# Consultee Comments for Planning Application 24/00672/FU

Application Number: 24/00672/FU

Address: Archways Sicklinghall Road Wetherby LS22 6AA

Proposal: Partial demolition of existing dwelling; front side and rear extensions with raised patio areas to rear; hard and soft landscaping works

Drawing Title
Proposed Ground Floor Plan
Job No. Dwg No.
2777 (PL)006
Date drawn Status
Jan 2024 PLANNING

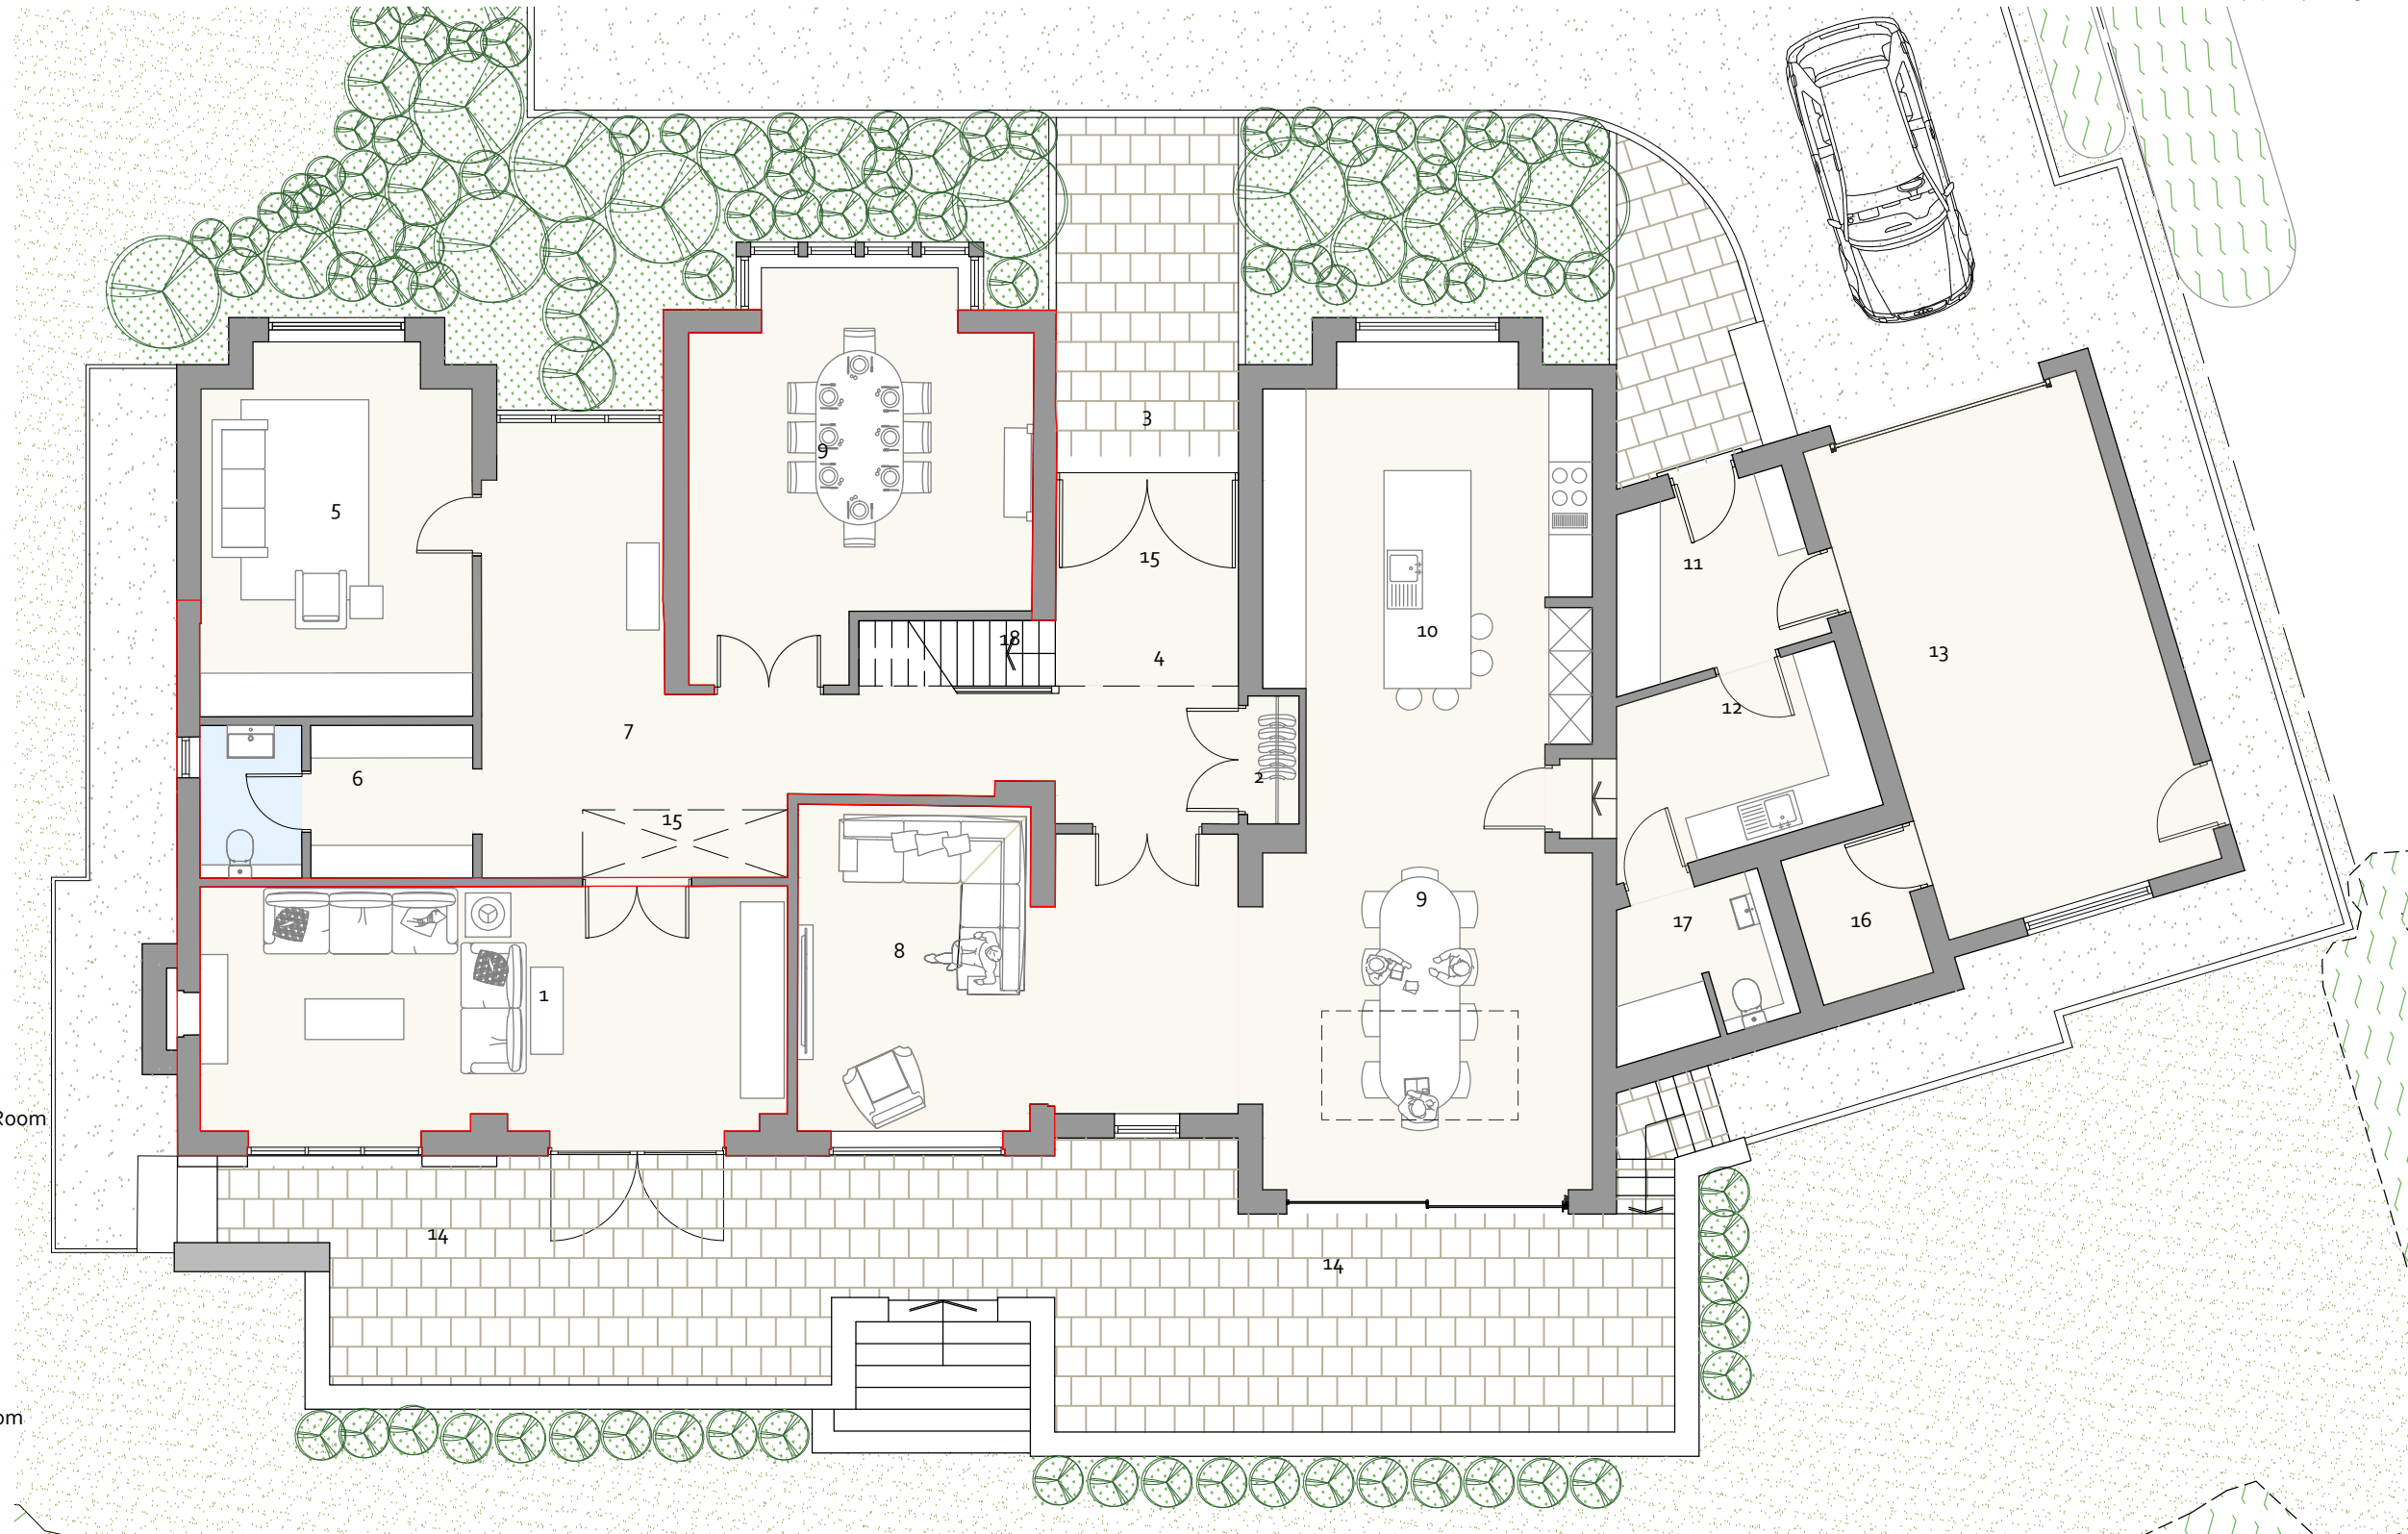
This is a relatively small plot by Linton standards and the proposed extension fails to retain substantial garden space around the dwelling, particularly on the eastern boundary. This is contrary to the characteristics of the area and contrary to the design policy contained within the Neighbourhood Plan.
